## DEPARTMENT OF PLANNING AND DEVELOPMENT

September 11, 2002

RE: Waiver Request 36-38 Waterville St. (017 E015) Building Permit #020834

GUARD RAIL
36/35
NATICKVILLE ST

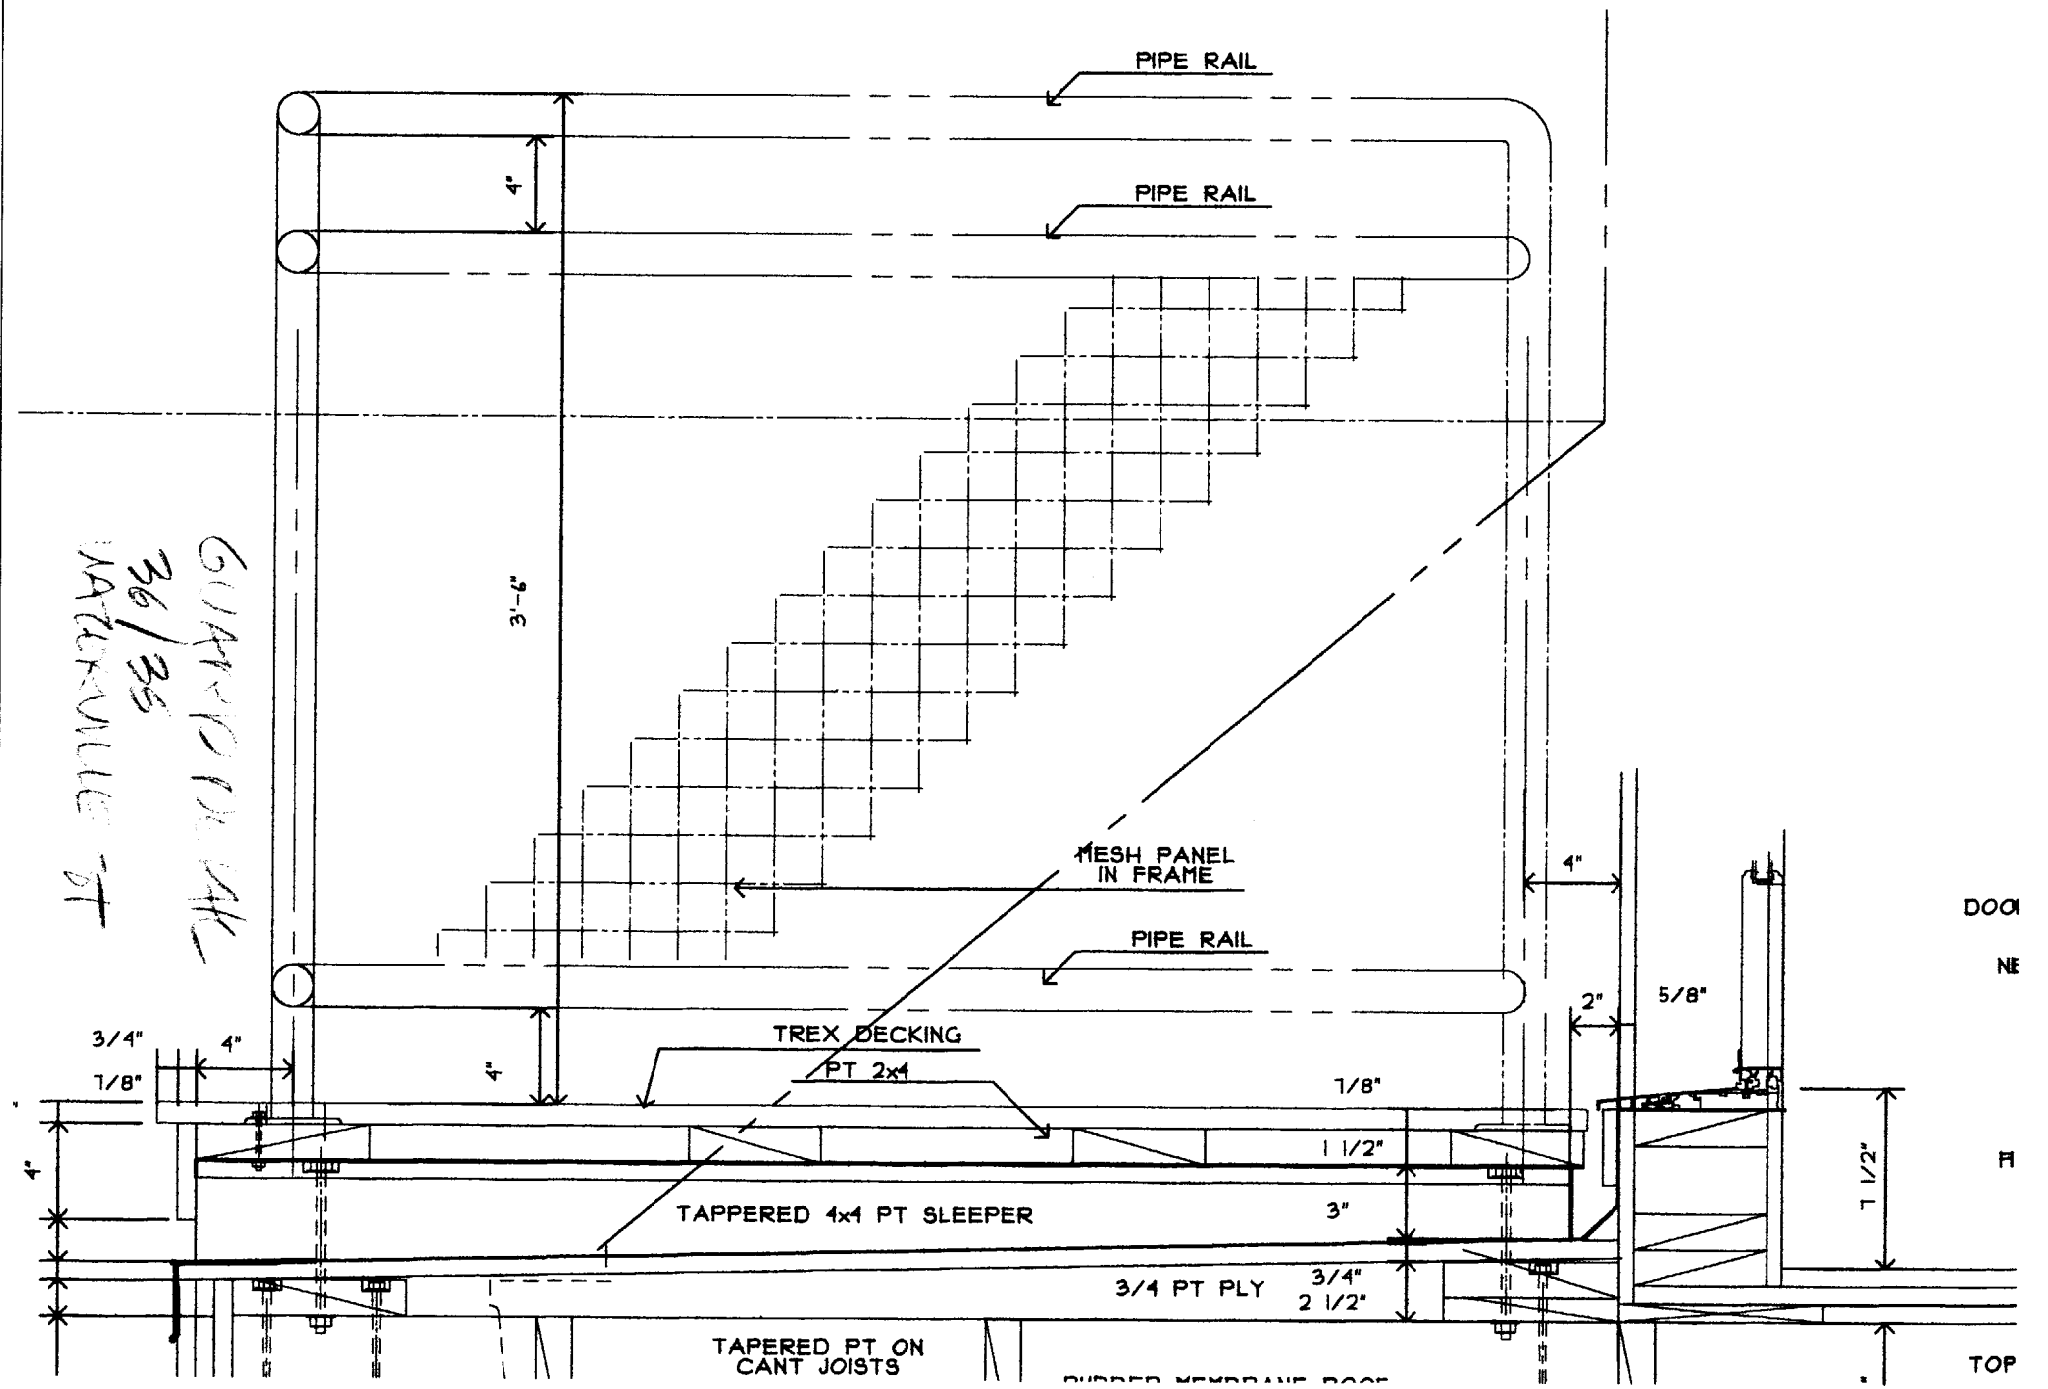
- 1)The openings on the north elevation must be limited to 10%. Because this is an NFPA 13R system, the code considers the openings unprotected and limited to 10%.
- 2)The Guards must be redesigned as the mesh has an ornamental pattern.
- 3)The owner agrees to install the NFPA type 13R system in the forth floor immediately and retrofit the entire building within 24 months of the issuance of a certificate of occupancy.
